SUBMISSIONS OF THE NATIONAL FARMERS UNION (NFU) AND THE LINCOLNSHIRE ASSOCIATION OF AGRICULTURAL VALUERS (LAAV) REGARDING THE TRITON KNOLL ELECTRICAL SYSTEM DEVELOPMENT CONSENT ORDER 201 [...]

PLANNING INSPECTORATE REFERENCE NO EN020019

SUBMISSIONS OF THE NFU & LAAV IN ANSWER TO QUESTIONS DCO 3.1, DCO 3.2, DCO 3.15; CA 3.3, CA3.13, CA 3.14; Eon 3.2, Eon 3.3, Eon 3.4 Eon 3.5 and LVI 3.3, SE 3.1, SE 3.2 and SE3.7. OF THE EXAMINING AUTHORITY'S THRID WRITTEN QUESTIONS

DATE 17th February 2016

**Figure 4: Indicative cross section of onshore export cable corridor**

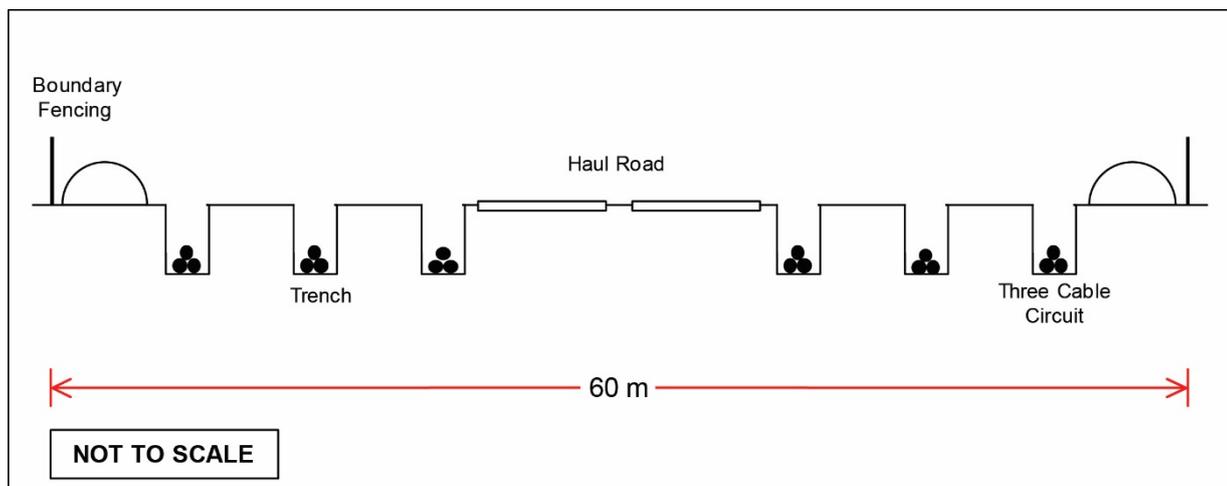
2.4 It is NFU/LAAV understanding that cables will be buried below field drainage. This was not clarified by TKES at the meeting on 4th February.

3.1 The NFU/LAAV still believe that cables should be buried to a depth of 1.5m especially after holding a meeting with farmers and their agents on 11th February when issues were raised over the depth only being 1.2m.

4.1 As stated in the minutes from the meeting on the 4th February with TKES the NFU/LAAV is still concerned at how landowners will know that TKES only need a 40m easement instead of 60m when crossing a field and that the cables will be constructed within this reduced width. After raising this issue at the hearings and asking again for clarification at our meeting on the 4th February no documentation has been forthcoming from TKES.
